Recommendation Report for Planning Permission for Works or Extension to a Dwelling

REF NO: AW/249/25/HH

LOCATION: 43 Leonora Drive  
Pagham  
PO21 3NH

PROPOSAL: Single storey rear extension, cladding to some external walls and changes to fenestration.

Proposed Extension and Alterations
at 43 Leonora Drive, Bognor Regis
for Mr and Mrs I Fridlington
Drawing P01 October 2025 Scale 1:100 & 1:1250 @ A3
Proposed Drawing - Floor Plan, Elevations & Location Plan

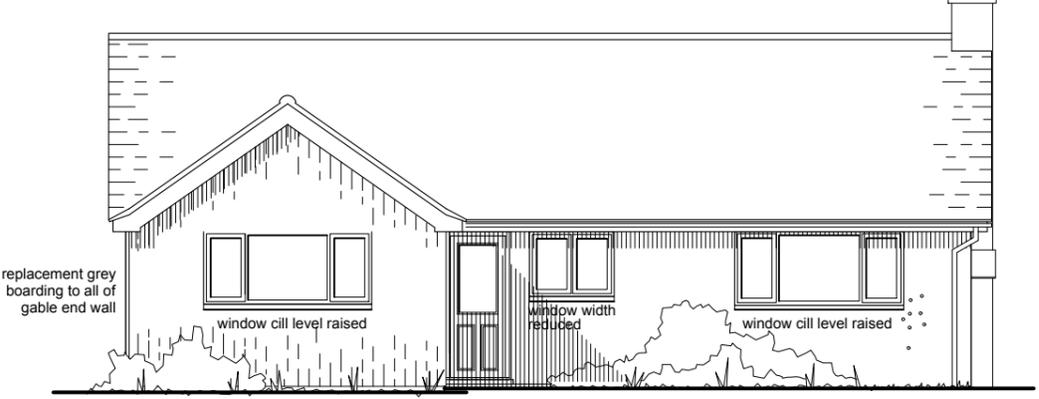
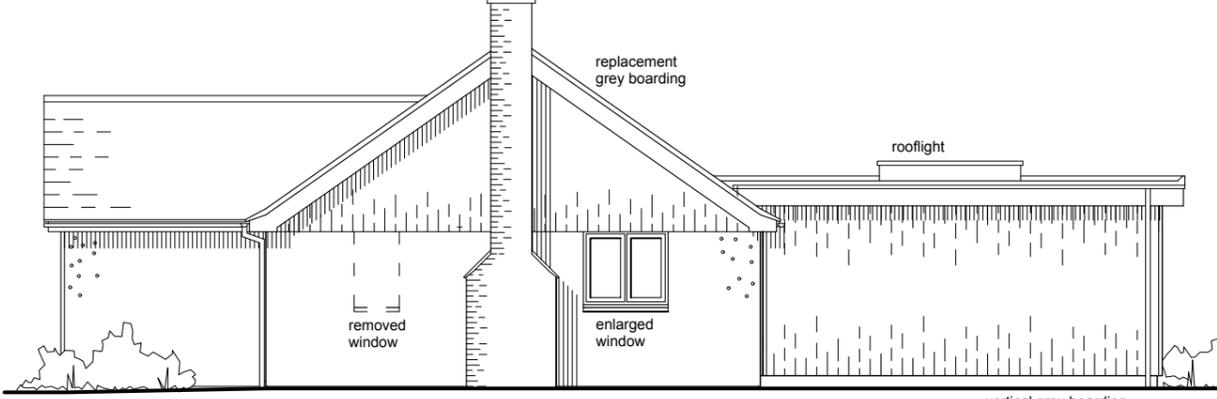
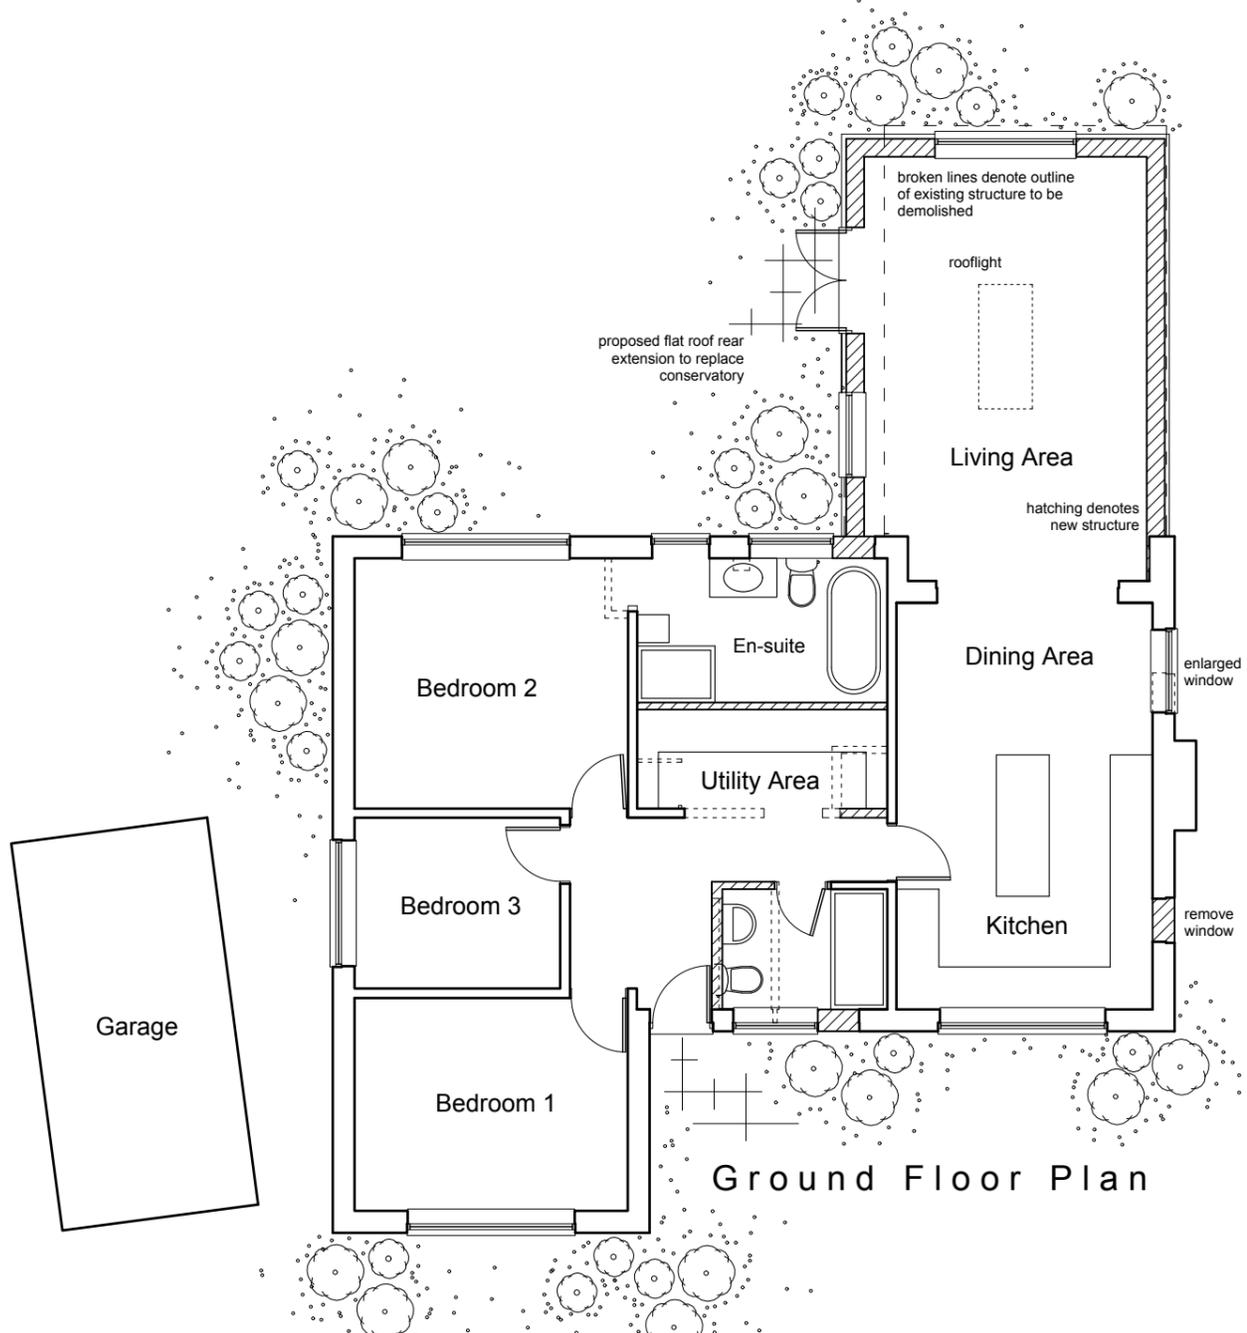
The proposed rear extension would have a flat roof with an eaves height of 3.05m, a depth of 6.35m and a width of 4.65m. It should be noted that the proposed extension would exceed the width of the existing conservatory by 0.6m, would extend 0.1m less from the rear wall of the dwellinghouse and would be lesser in height by 0.2m. The rear extension would have patio doors and a window on the north

elevation. There would also be a rooflight and a window on the rear (west) elevation. The proposal would be better integrated, both in design and material palette, than the existing conservatory and would constitute a more logical extension of the property. The Arun Design Guide (ADG) advised that rear extensions should not project further than 3.3m. While this proposal would exceed this guidance, the extension would not be harmful to visual amenity and character.

The application proposes amendments to and additional fenestration separate to the rear extension. It is proposed to raise the sill level of windows serving bedroom 1 and the kitchen, as well as reducing the width of the window serving the toilet. It is proposed to enlarge the window serving the dining area and remove the window serving the kitchen on the south elevation. On the east elevation, it is proposed to replace the window serving the ensuite and replace the door which previously served the kitchen with a full-length obscure-glazed window. The minor changes to fenestration are acceptable in both in design and scale.

The height of the extension would be less than the existing conservatory and a spacing of 1.1m would be maintained to the southern side boundary. The neighbouring property to the south has a double garage which is constructed close to the shared boundary with the application site. The proposed rear extension would not extend beyond the existing neighbouring garage. As such, the proposed rear extension would not result in overshadowing or overbearing impacts to the neighbour to the south.

As the proposal would replace a conservatory, there would be no additional overlooking at the rear of the property. The enlarged window on the south elevation would not affect the residential amenity of 45 Leonora Drive, owing to the proximity and massing of the garage of this neighbour. The proposal is acceptable in terms of neighbouring amenity, in accordance with policy D DM4 of the Arun Local Plan.

Proposed Extension and Alterations
at 43 Leonora Drive, Bognor Regis
for Mr and Mrs I Fridlington
Drawing P02 October 2025 Scale 1:100 & 1:500 @ A3
Proposed Drawing - Roof Plan, Elevations & Block Plan

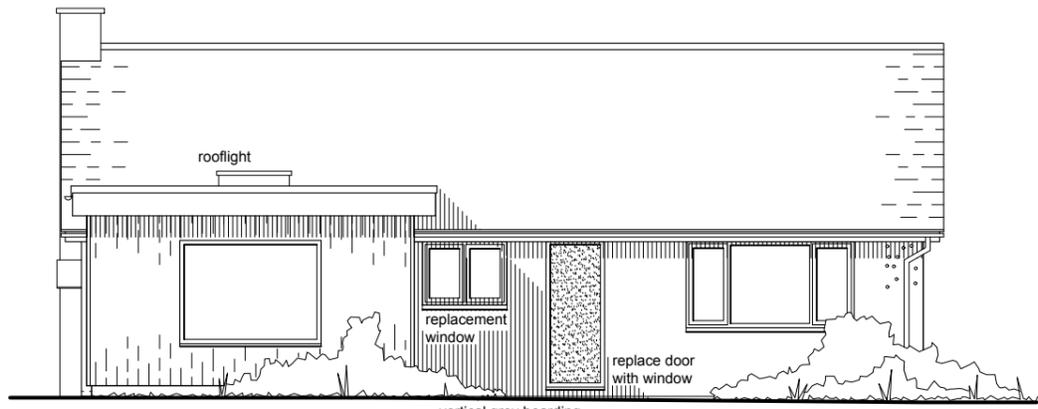
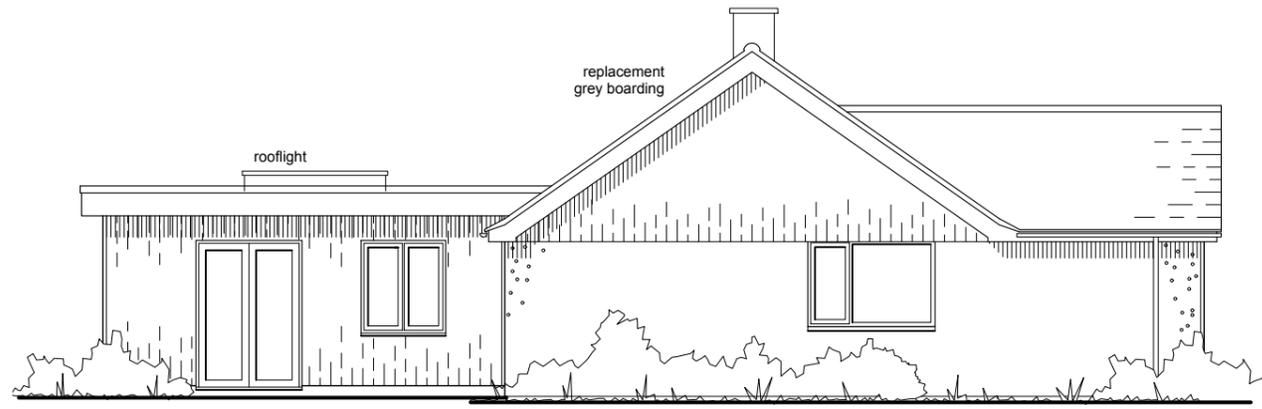
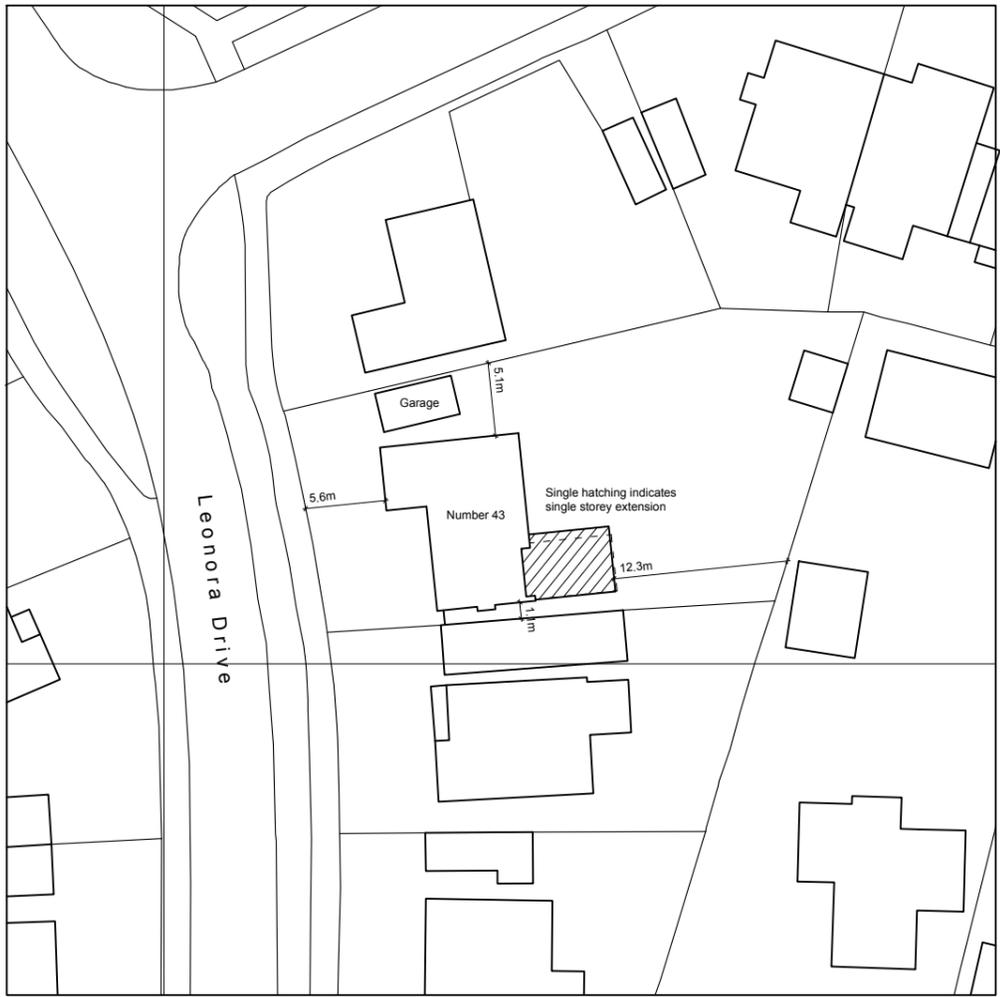
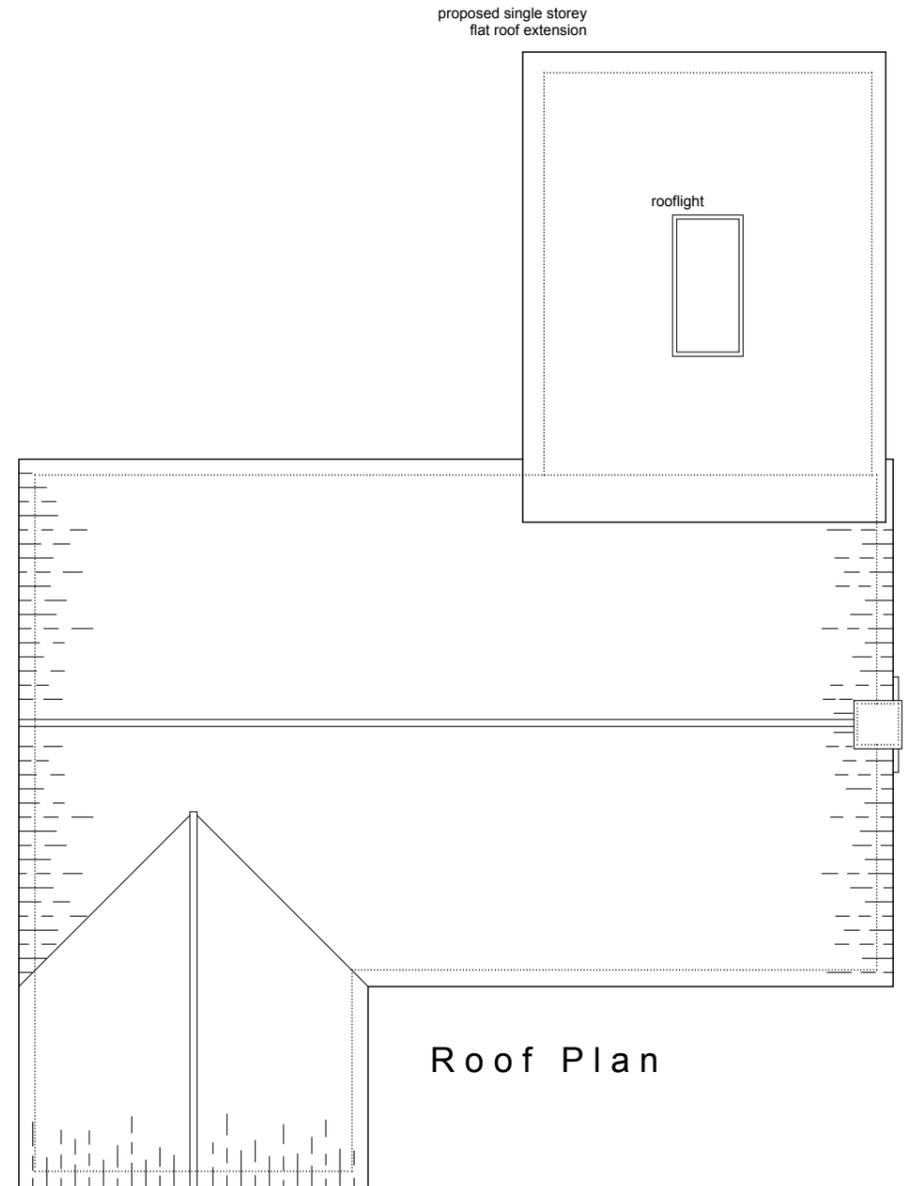
Grey composite boarding is proposed on the front gable projection, rear extension and gable ends above ground floor level. This would be darker in contrast with the existing white UPVC boarding. Properties on Leonora Drive make use of cladding in various colours. The grey boarding would integrate well with the street scene and would not detract from the character and appearance of the locality. The proposed cladding is therefore in accordance with Arun Local Plan (ALP) policy D DM1 and D DM4.
